Appeal Decision

Appeal Ref: APP/R5510/W/21/3283960

Ruislip Nursing Home, 173 West End Road, Ruislip HA4 6LB

- The appeal is made under section 78 of the Town and Country Planning Act 1990 against a refusal to grant planning permission.
- The appeal is made by Mr Cader, Ruislip Nursing Home against the decision of the Council of the London Borough of Hillingdon.
- The application Ref 19817/APP/2021/914, dated 9 March 2021, was refused by notice dated 20 April 2021.
- The development proposed is new front entrance porch.

DRAWING  
**EXISTING PLAN & ELEVATIONS**

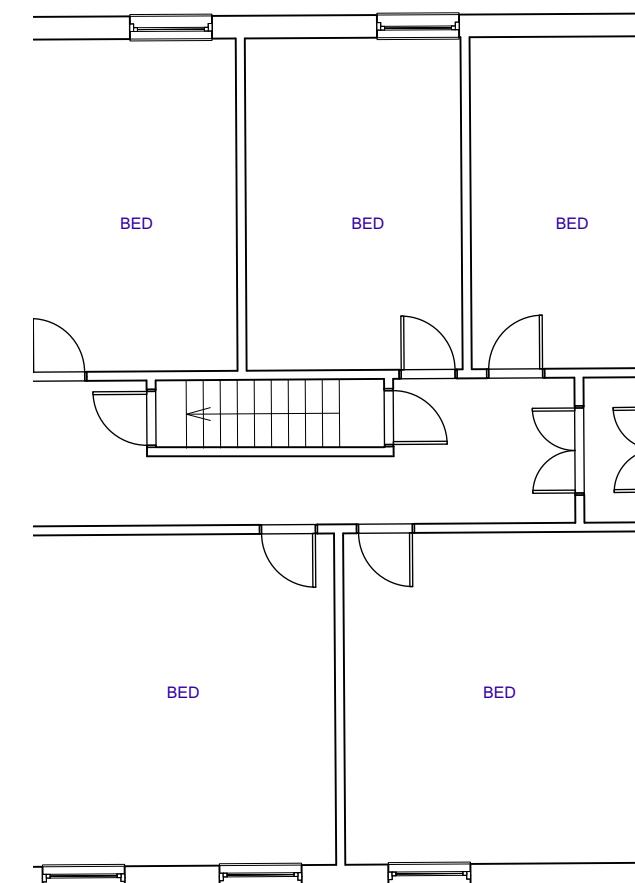
5. The building has distinctive features including a steep pitched hipped roof with finials along the ridge; gold brick exterior with red brick dressings and string course; and gauged brick surrounds to windows and an arched door entrance. Despite a fairly large modern rear extension and side projection, these result in an attractive and well-proportioned building, particularly when viewed from the street to the front. In my view, the architectural and historic interest of the building as an example of a former farmhouse dated by the Local List entry to around 1872 add much to its significance as a non-designated heritage asset.

6. The proposed porch would be of modest scale with a roof form and external materials that would be generally sympathetic to those of the host building. Nevertheless, I consider that the projection of the roof above the string course between the building's floors and larger entrance doors would be visually

jarring and would result in an awkward relationship with the host building. The development would additionally obscure views of the existing arched door entrance which adds to the distinctive appearance and thus significance of the building. In contrast to existing extensions which are to the rear or set back from the front elevation of the building, the porch would be readily visible from the street scene increasing the visual impact of the development. In combination, I find that these factors would result in a discordant development that would harm the character and appearance of the building, and that there would be consequent detriment to the character and appearance of the area.
